WEST SUSSEX COUNTY COUNCIL CONSULTATION

TO:	Arun District Council FAO: Michael Eastham
FROM:	Highways, WSCC
DATE:	19/07/2018
LOCATION:	Land to the West of Church Lane, South of, Horsemere Green Lane, Climping
SUBJECT:	CM/13/18/OUT Outline application with some matters reserved for the erection of up to 300 dwellings and ancillary development comprising open space, a building within use class D1 of up to 875 square metres net, a building for A1 use having a floor area of up to 530 sq. metres net, together with open space and ancillary works, including access points, car parking and drainage arrangements, with appearance, landscaping, layout; and scale wholly reserved for subsequent approval. The access detail, showing the points of access to the development, and indicated on Bellamy Roberts drawings numbered 4724/013 and 4724/005 Rev A are access proposals to be determined at this stage of the application. For the avoidance of doubt all other access detail within the site is to be determined as a reserved matter at a later stage. Resubmission following CM/1/17/OUT. Departure from the Development Plan. More information.

PROJECT			
Mulgrave Estates			
TITLE			
Land at Climping, West Sussex			
Proposed Roundabout			
DRAWN BY	DESIGN BY	CHK BY	DATE
JCB	GDB	GDB	23/03/16
SCALE	4724 / 002	B	1:825 @ A1 1:1250 @ A3

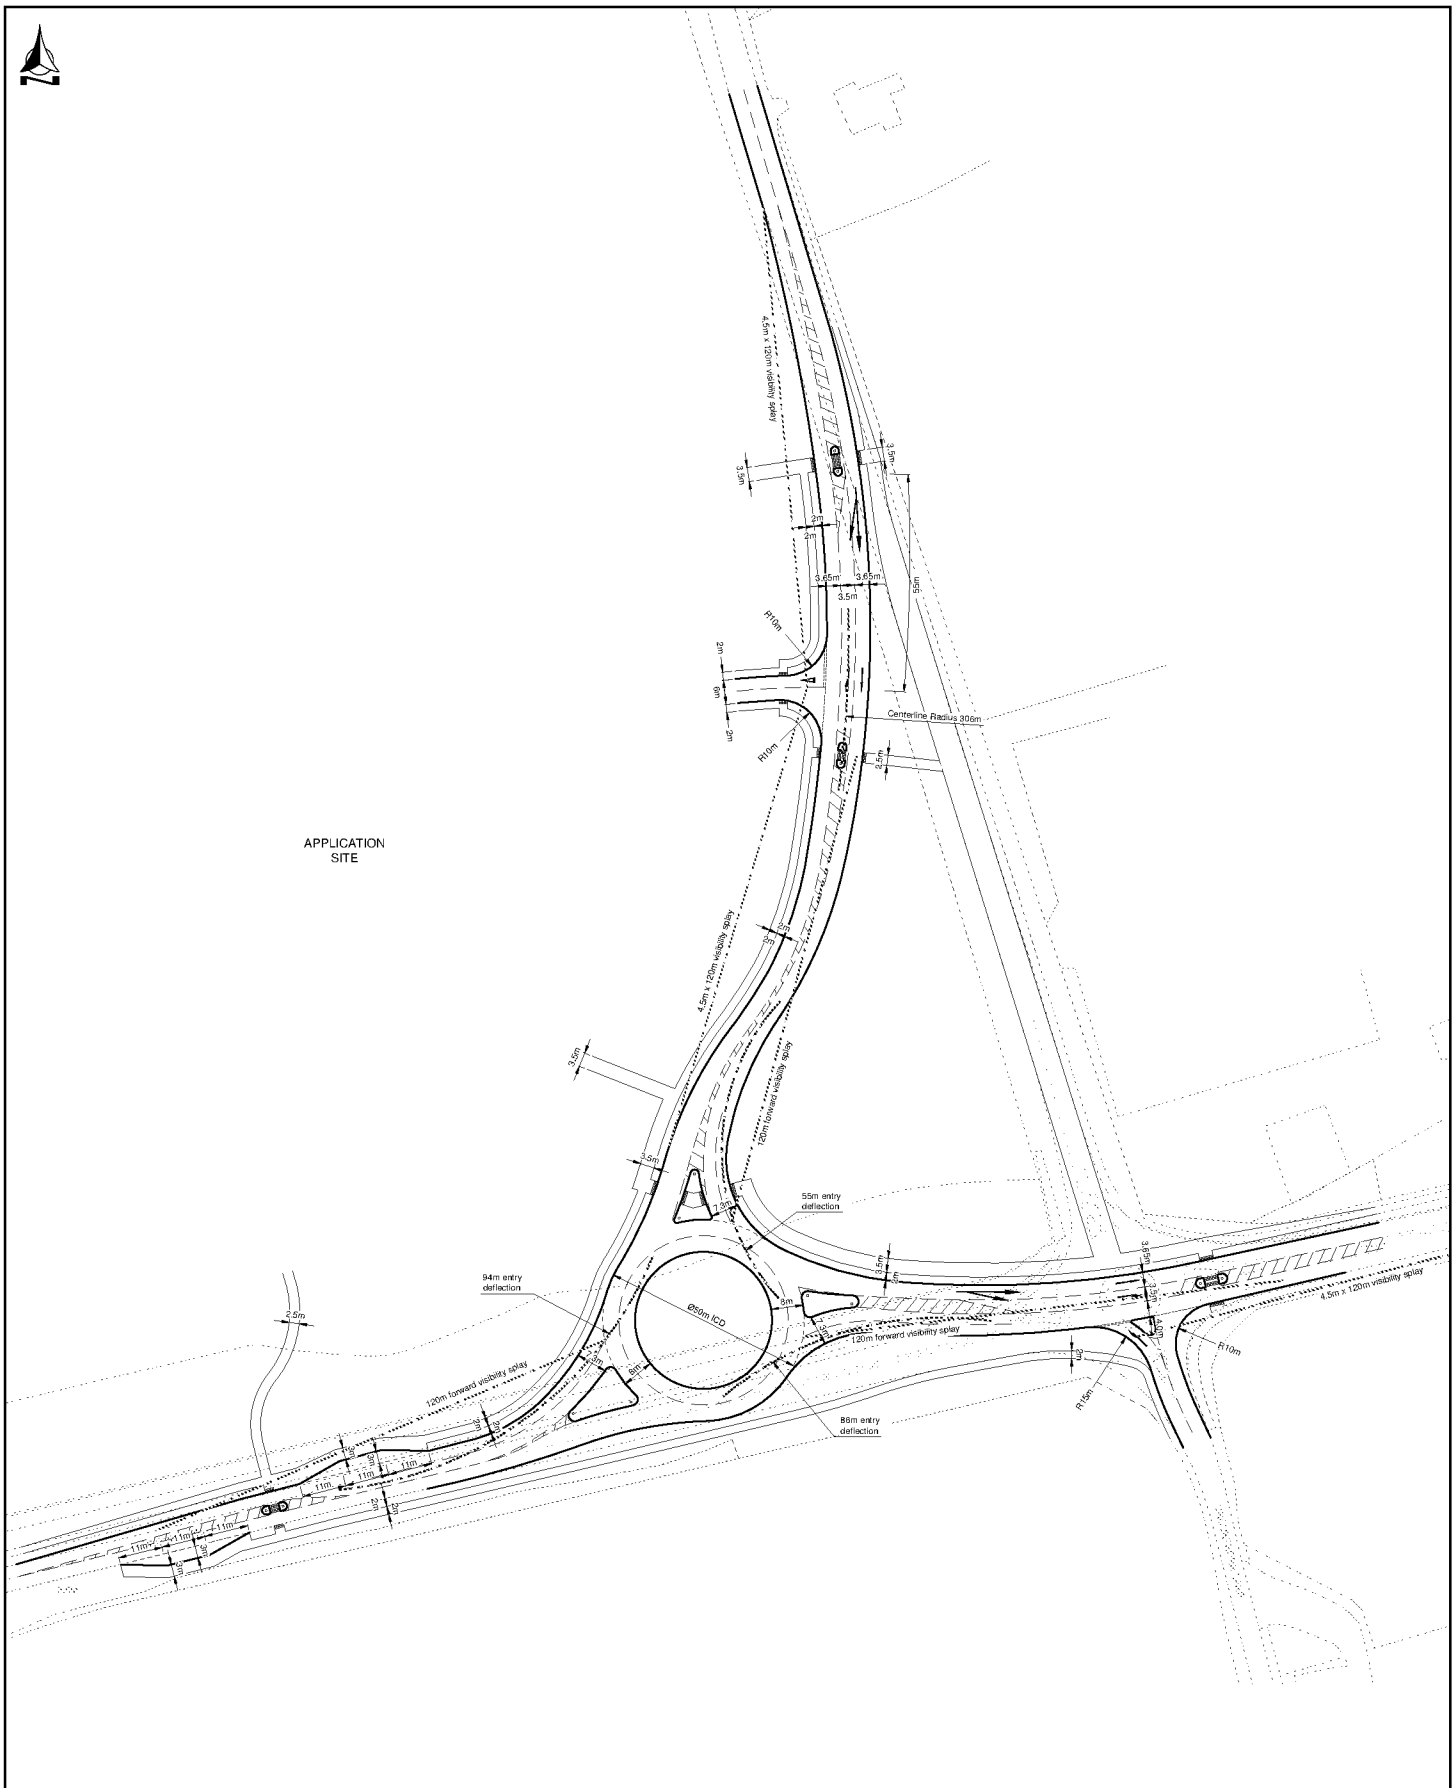
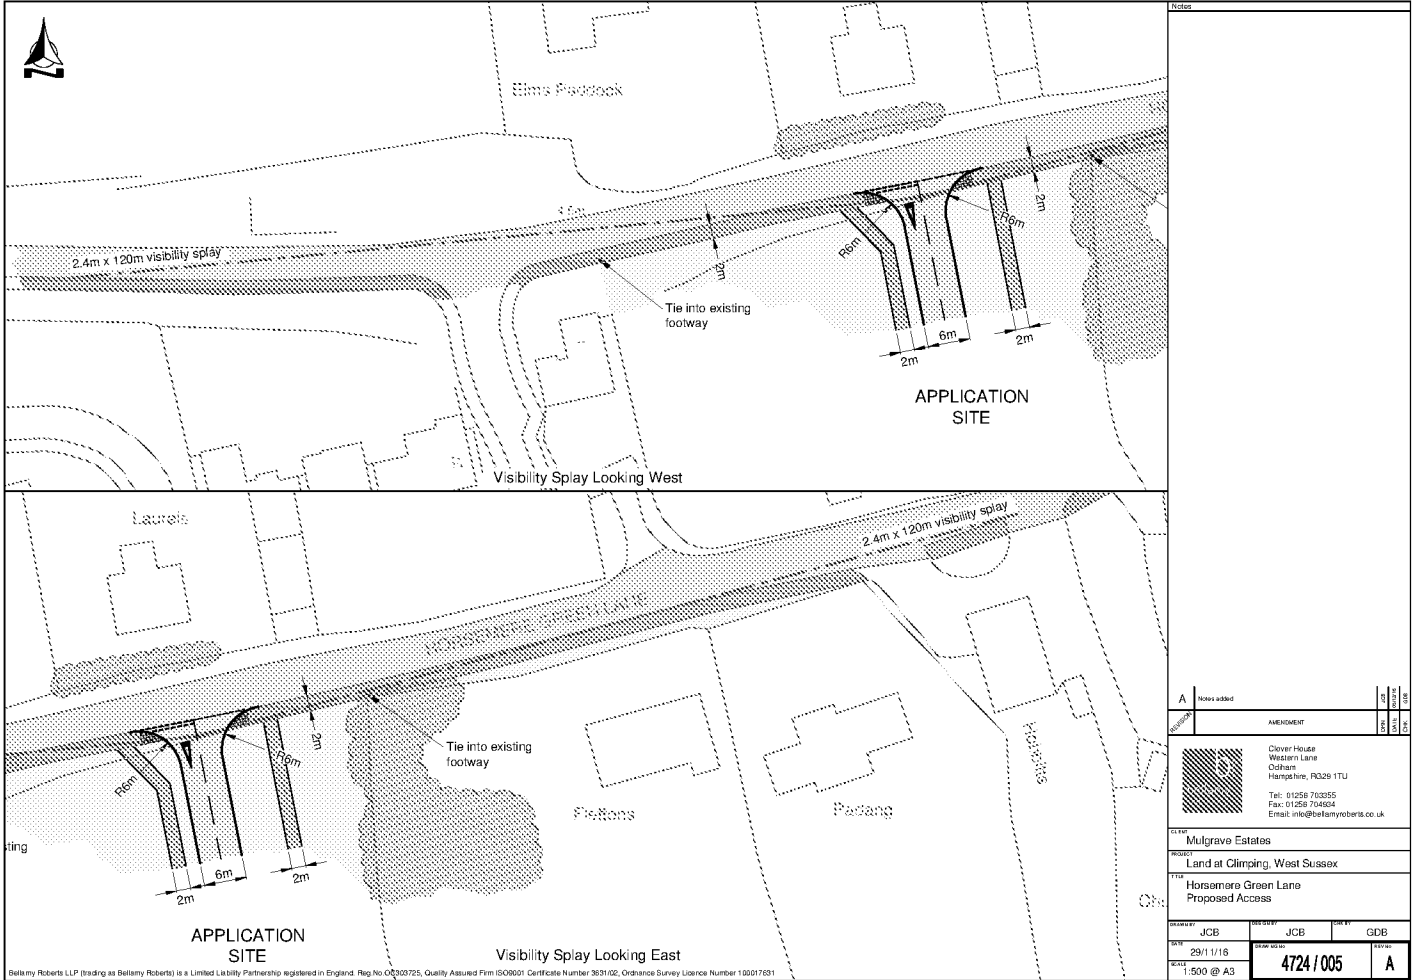
The applicant has provided a revised Stage 1 RSA to take account of the proposed change from a pedestrian refuge to a signalised crossing of the A259. The majority of the issues raised in the RSA can be dealt with at detailed design stage such as anti-skid material and the design of tactile paving. The Highway Authority would however look for confirmation that the applicant is going to provide a toucan crossing facility rather than a puffin crossing and that a 3m in width shared pedestrian/cycle route will be provided on the southern side of the A259 from the crossing facility to the junction of Crookthorn Lane.

The Highway Authority would look for confirmation that the applicant is going to provide a toucan crossing facility rather than a puffin crossing and that a shared pedestrian/cycle route will be provided on the southern side of the A259 from the crossing facility to the junction of Crookthorn Lane.
